has permission to Replacement Subsurface System 45 Winding Way

Job ID: 2011-01-248-SUBSRF REPAIR

Replacement System Variance Request

Subject: Approval, Replacement System Variance Request, Wainwright Property, 45 Winding Way, Peaks Island, Portland

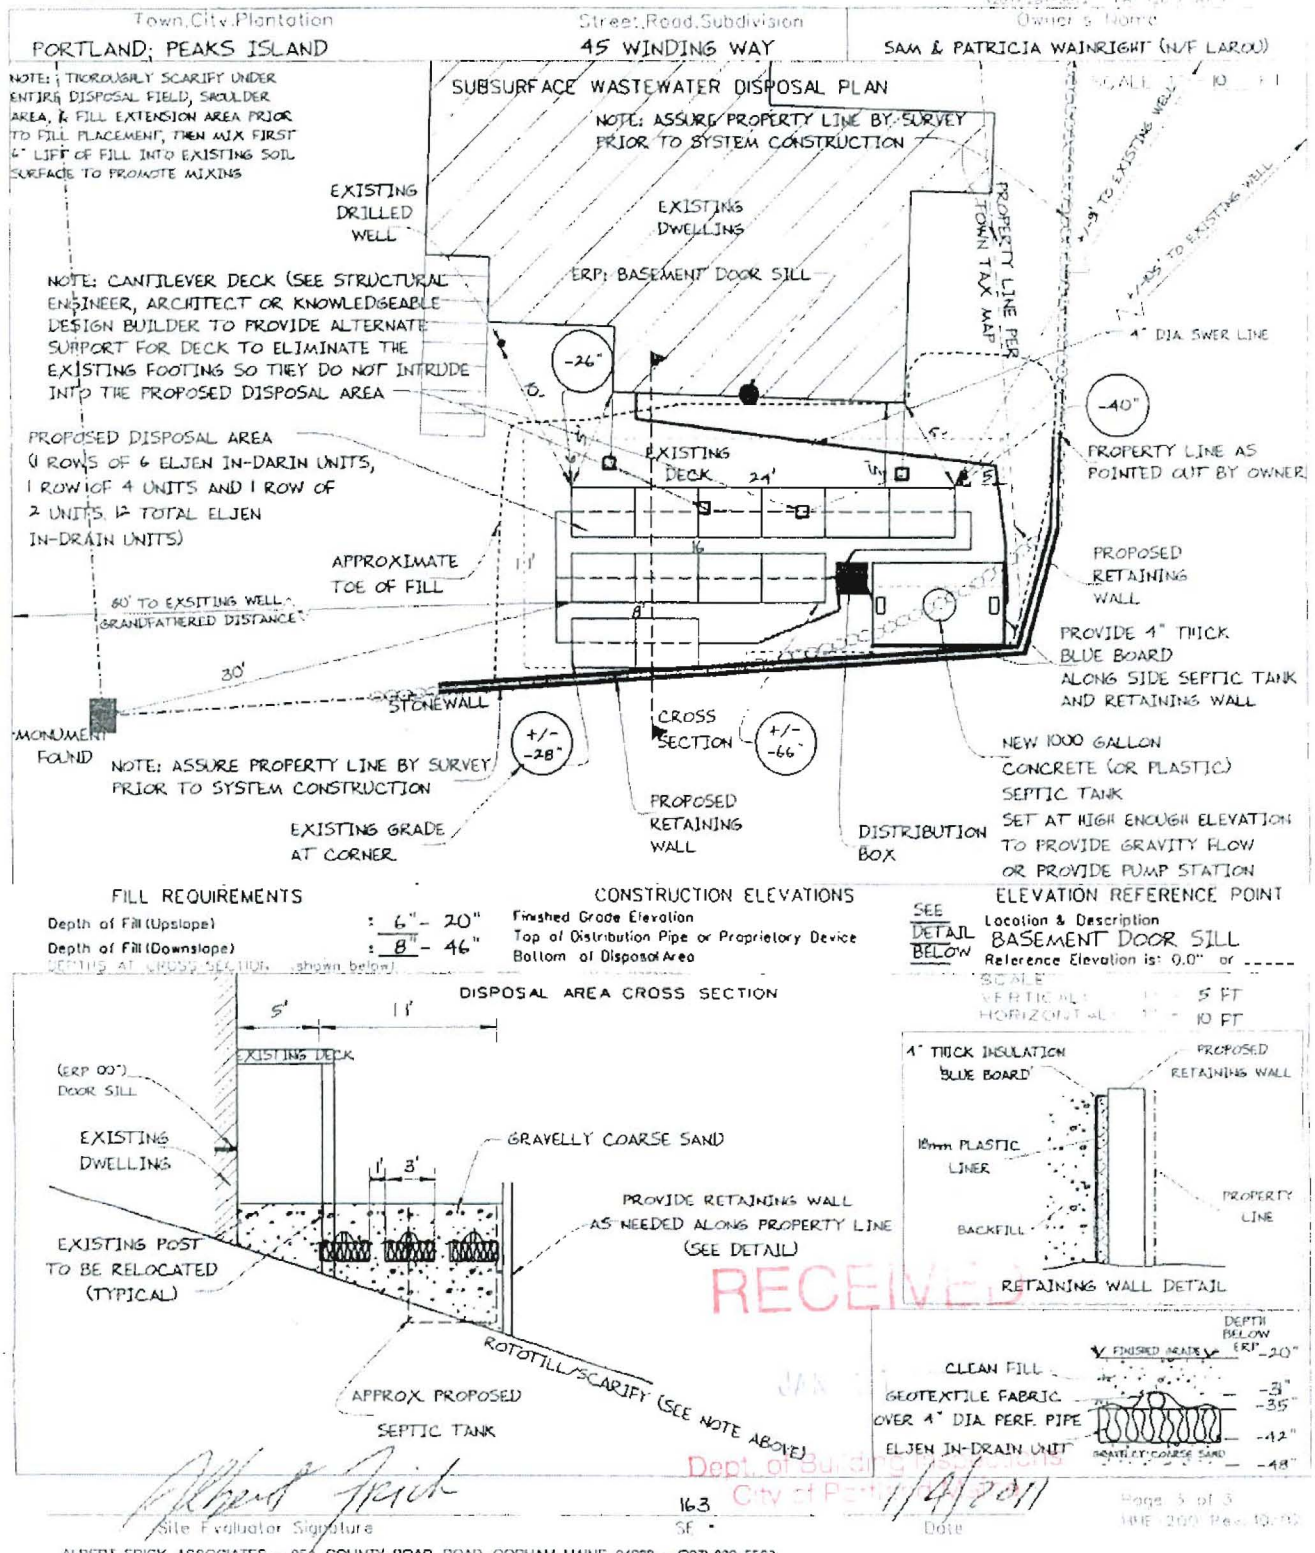
1. To reduce the setback from the proposed septic tank to a potable water supply, and a property line, from 50 feet and 10 feet to 22 feet and 1 foot, respectively.
2. To reduce the setback from the proposed disposal area to a potable water supply, a non-full foundation, and a property line from 100 feet, 15 feet, and 10 feet to 10 feet, 5 feet, and 1 foot, respectively.

A retaining wall is proposed along the subject property to accommodate these setback reductions.

By copy of this letter we hereby authorize the Local Plumbing Inspector to issue a permit for the replacement system installation as proposed on the above referenced HHE-200 Form. Work must be completed in a timely manner and you or your installer are responsible to notify the Local Plumbing Inspector when you are ready for the necessary construction inspections. In all aspects **beyond those noted** in this letter the installation shall conform to the requirements of the Rules.

Further, the Division recommends at least an annual water quality test of the well, due to the severely reduced setback.
